Consultation Response from KC, Conservation & Design

2023/91676 90, New North Road, Edgerton, Huddersfield, HD1 5NE

Listed Building Consent for change of use of offices to bed and breakfast, lightwells and new window opening to sides(within a Conservation area)

Date Responded: 13.10.2023

PROPOSED EACH SHOWER
INTERNAL PODS AND W/C

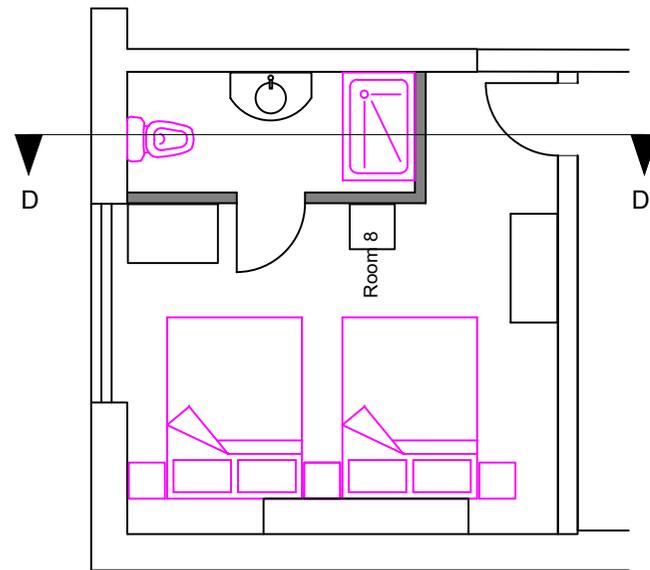
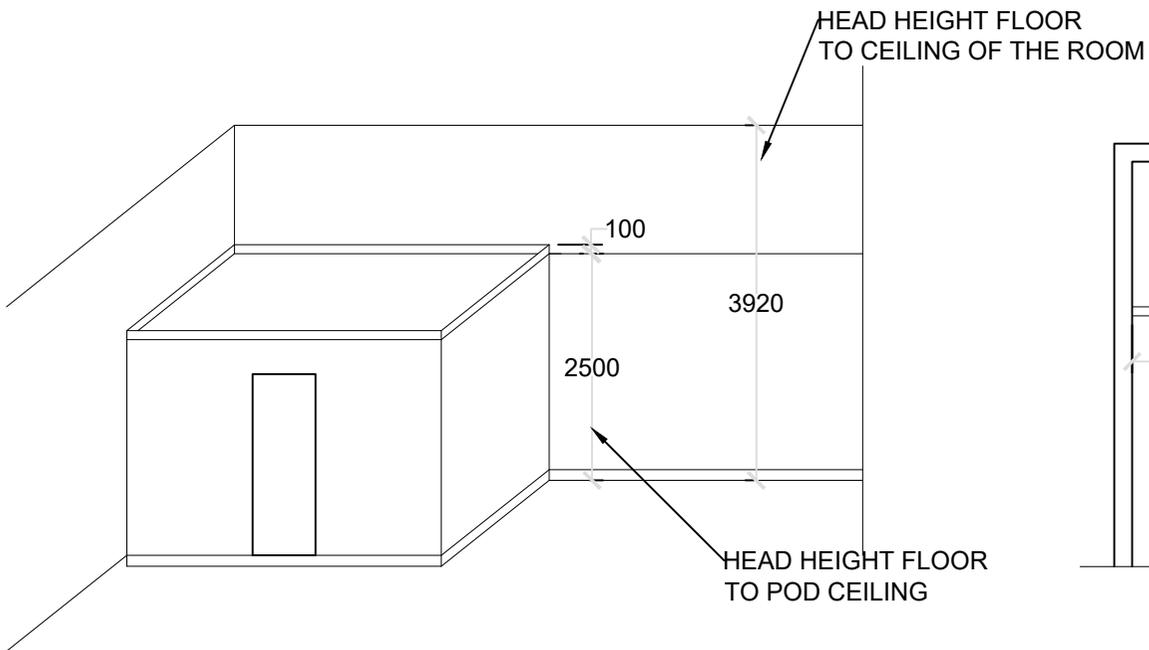
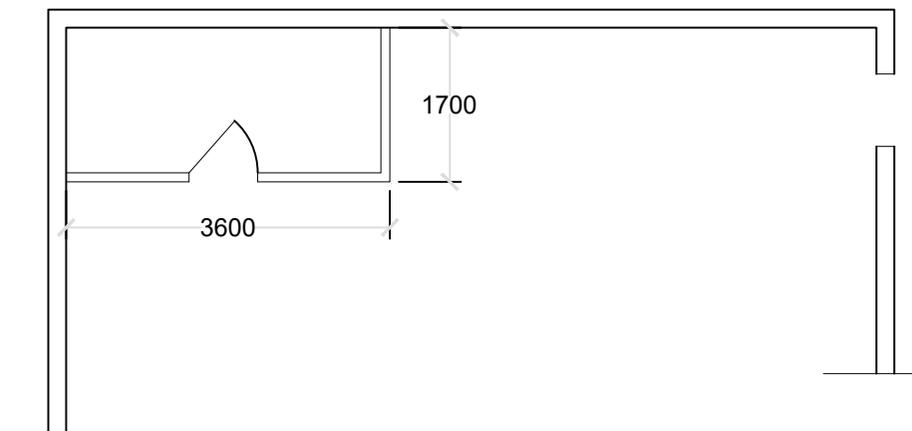
- Ensuites – an indicative section drawing has been submitted to show a ‘typical’ ensuite pod. However, this does not provide sufficient detail to assess the different room types and the impact on architectural details. Example areas of concern are summarised below:
 1. Room 6 on the ground floor and room 10 on the first floor – the interaction of the ensuites with chimney breasts (not shown on the existing or proposed drawings) are unclear.
 2. Room 5 on the ground floor – the ensuite needs to be set back from the window architrave.
 3. All ensuite pods should be set below ceiling level to avoid cornices. This is unclear without section drawings of the ground and first floors.
 4. The impact of soil stacks and pipe runs through the historic fabric, in particular covings and cornices, needs to be provided.

- Notwithstanding the information submitted, plans, elevations and sections of the proposed shower pods and ensuites, along with associated pipework and services, shall be submitted for approval prior to commencement of these installations. No architectural detailing (including covings, picture rails, architraves, skirtings and chimney breasts) shall be removed or damaged without consent.

TITLE CHANGE OF USE FROM OFFICES TO BED AND BREAKFAST
PROPOSED FIRST & SECOND FLOOR PLANS

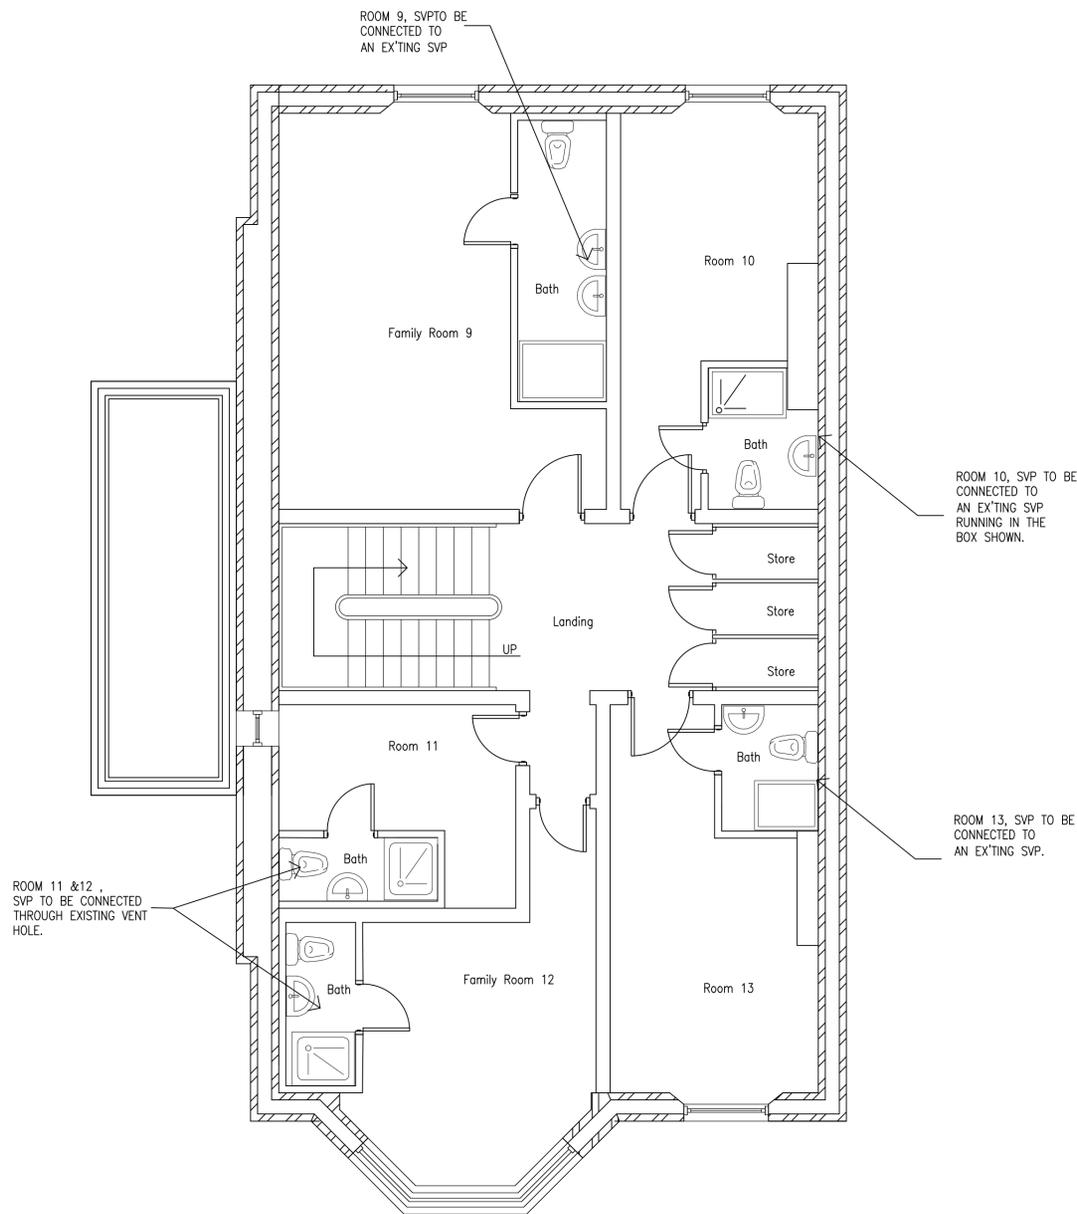
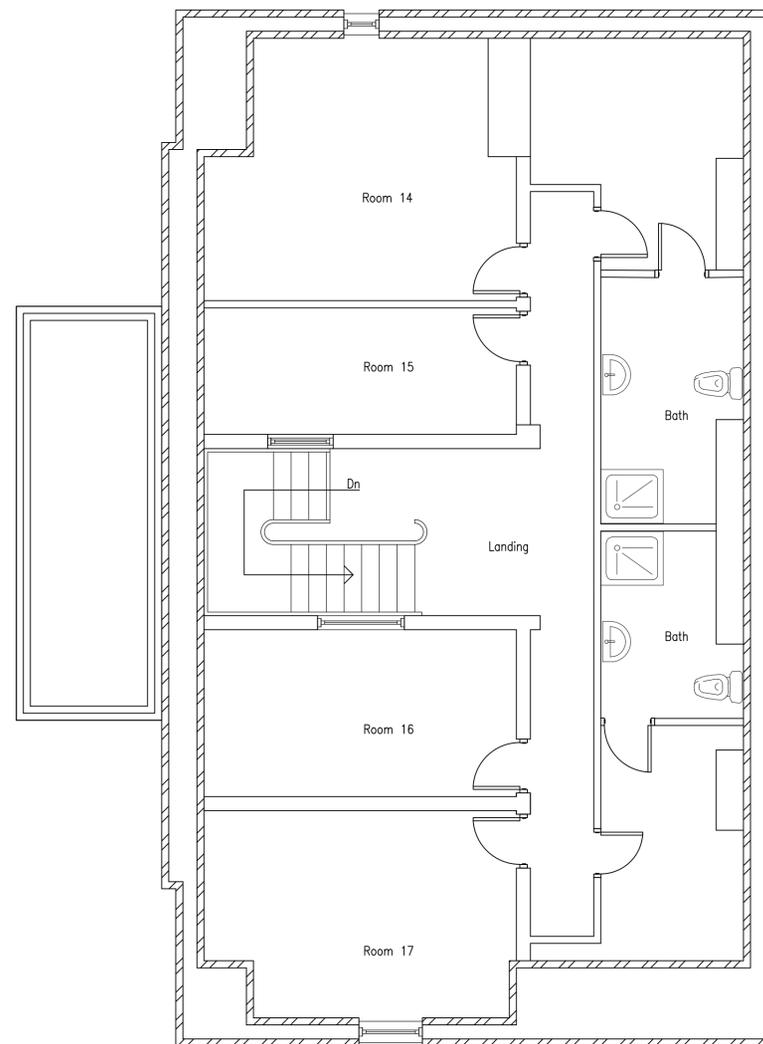
- First floor gable window – following negotiations, the first-floor window to room 9 has been omitted. The introduction of a small first-floor window to room 11 to the right of the stair window is simple in design and timber framed, with the ashlar stone surround matching the ground floor window opening below. The minor harm to significance is outweighed by providing natural light and ventilation into the existing room. **Condition.**

- Some elements of the drawings are unclear. There is no shower in room 2 in the basement, is this correct? Two doorways access room 7 on the ground floor, is this correct? Are the top floor shower rooms and WCs accessed via storerooms?
